DW/BG
15391
2 February 2017

The Secretary
NSW Department of Planning & Environment
320 Pitt Street
Sydney NSW 2000

**RESPONSE TO SUBMISSIONS ADDENDUM - SSD 7445
SITE 9, SYDNEY OLYMPIC PARK**

Drawing no. **DA02.001** Revision **A**

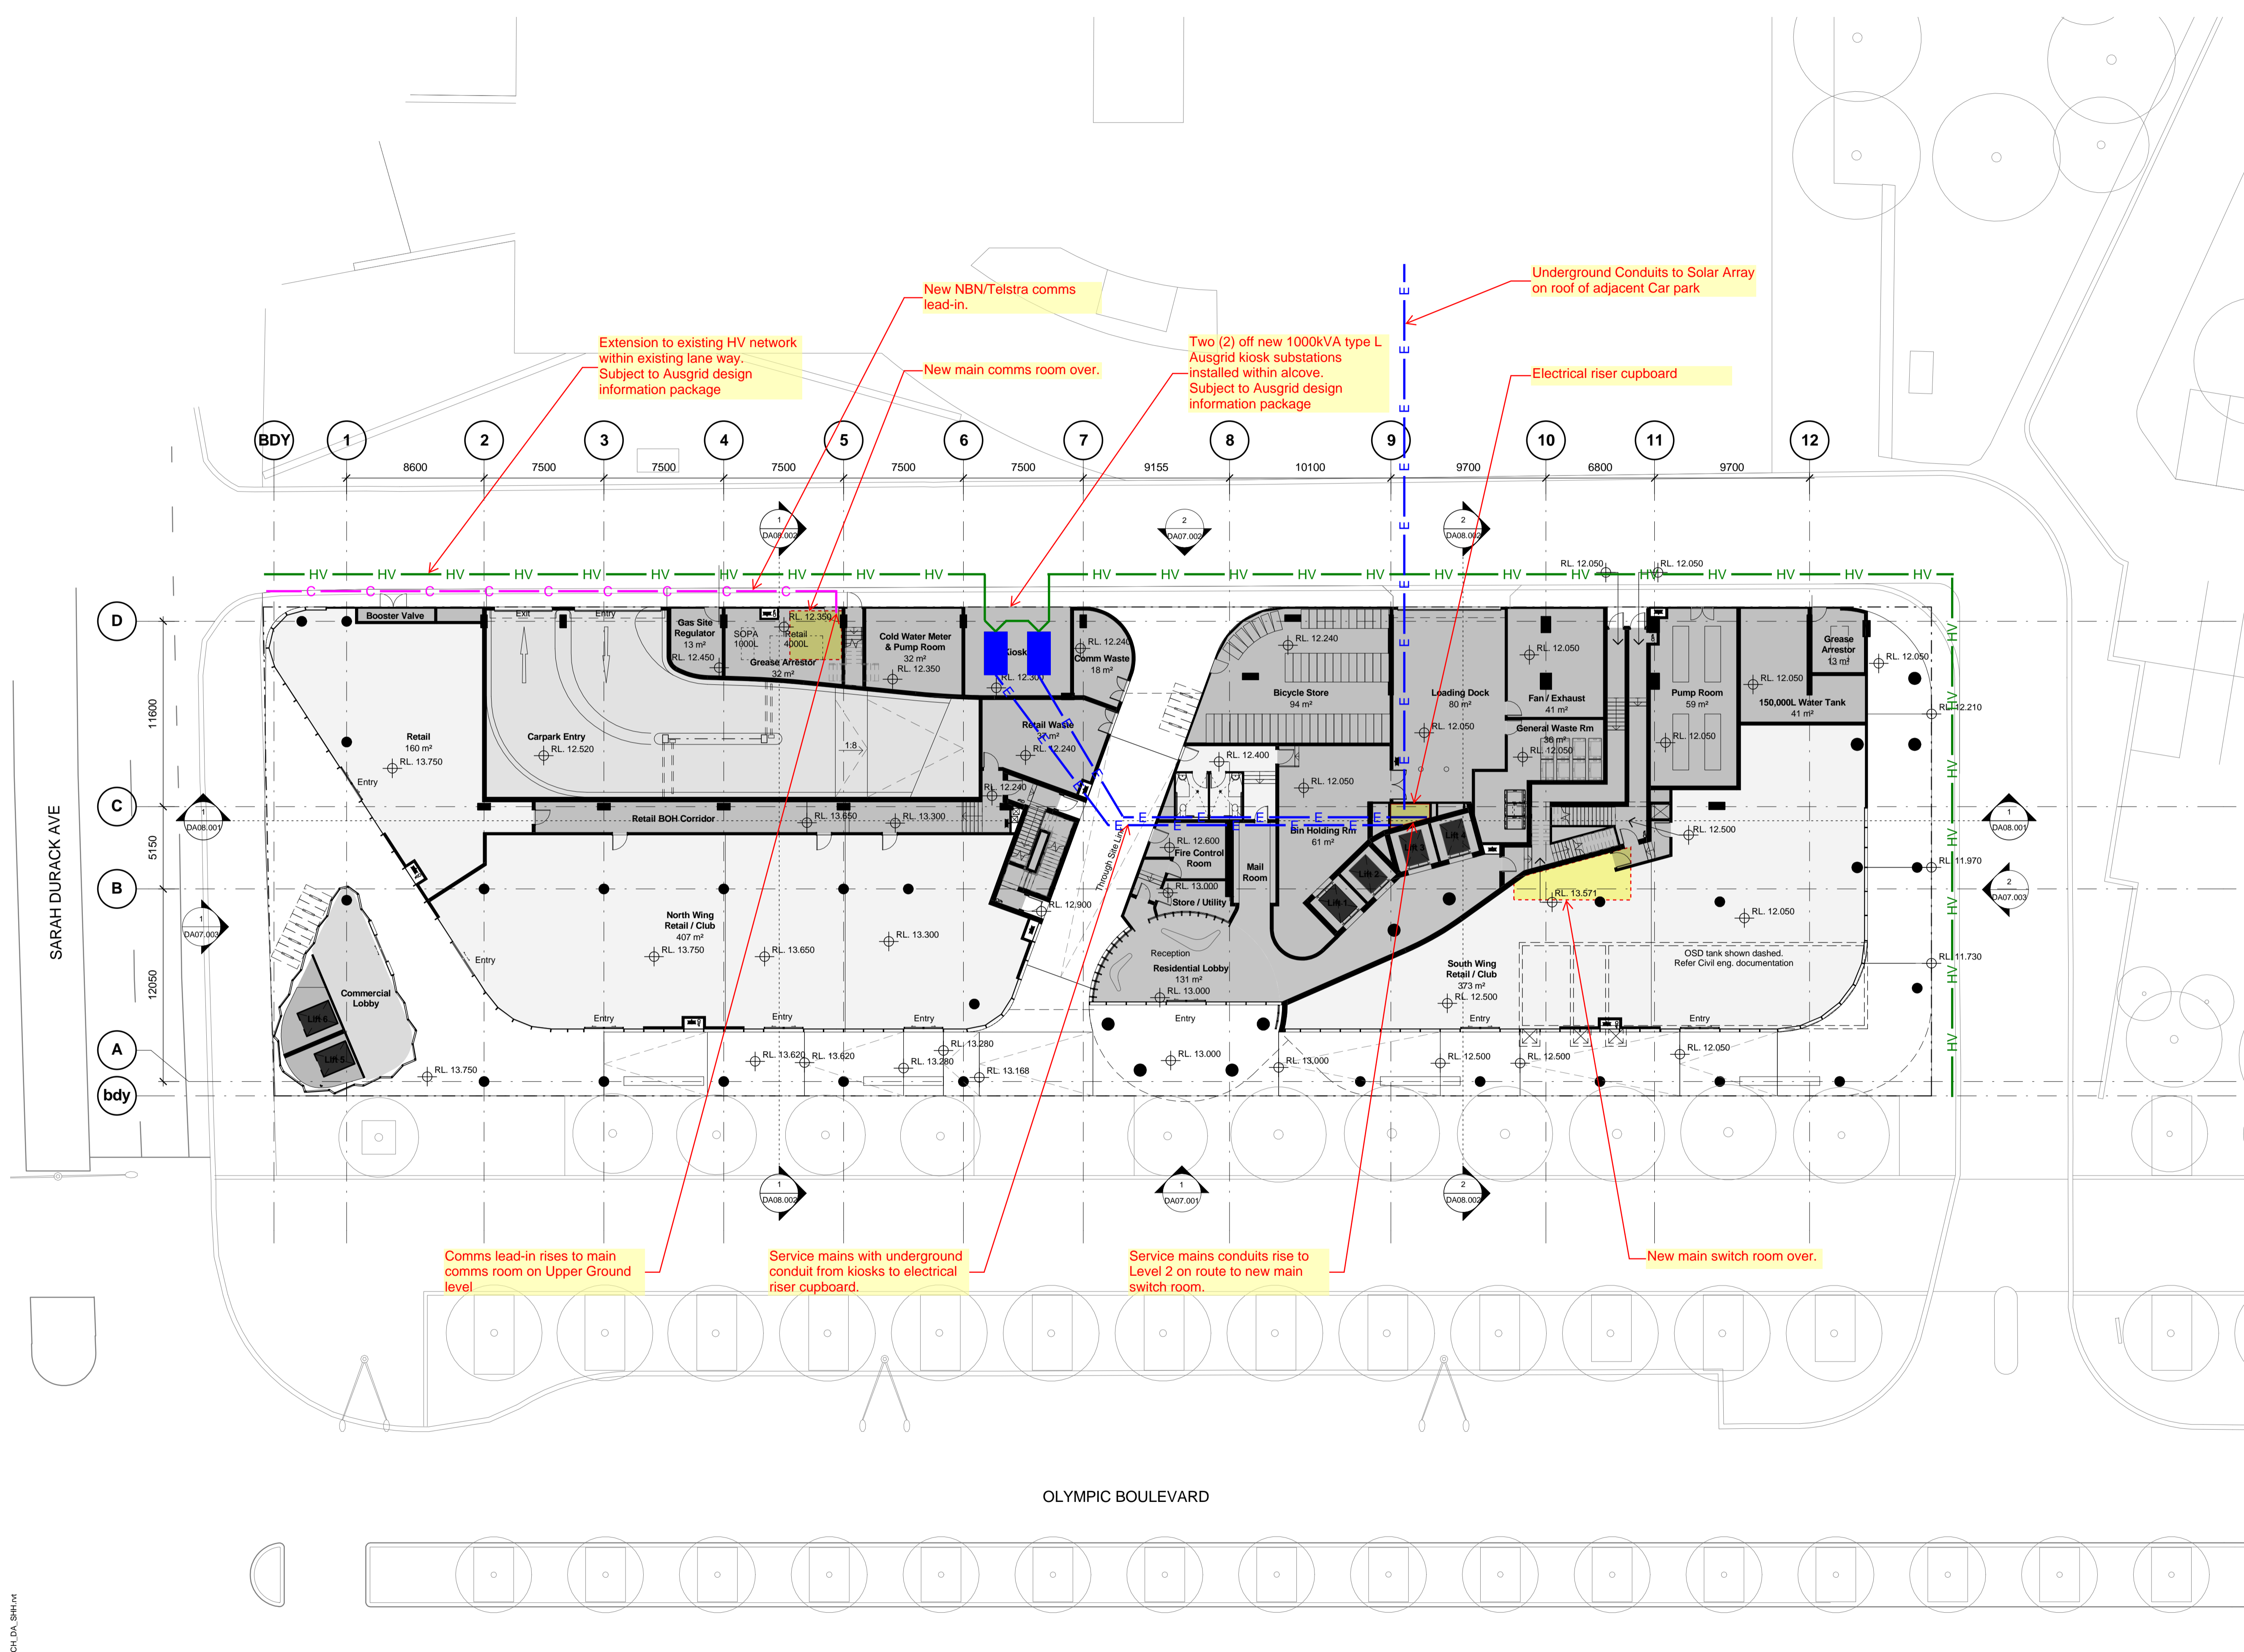
- *Consider the provision of the resident and employee bicycle parking on the ground level, with secure street access, access to end of trip facilities and direct access into the building.*

We note that bicycle storage was originally removed from the ground floor and replaced by retail floor space upon the request of DPE in order to improve the activation of the through site link. Following the latest request from DPE to provide some bicycle parking on the ground floor, the applicant has attempted to strike a balance to ensure ground floor activation is maintained whilst providing ground floor bicycle storage. This has also resulted in providing 8 bike spaces per floor in the podium in the storage areas and then replacing the converted storage areas in the podium on Level 09 by in turn converting some bicycle spaces into storage spaces. This spreads the bicycle parking provision from the ground floor up to Level 09, but with the majority of spaces provided on the ground floor that is accessible internally from the residential foyer. As such the architectural plans have been amended to accommodate this request as follows:

Ground

- New Bike Storage (reduced retail tenancy). Bike storage has door to the through site link and straight into the corridor leading into the mail room. **(+41 Bike Storage)**
- Retail tenancy area reduced.
- Retail waste room has area as before.
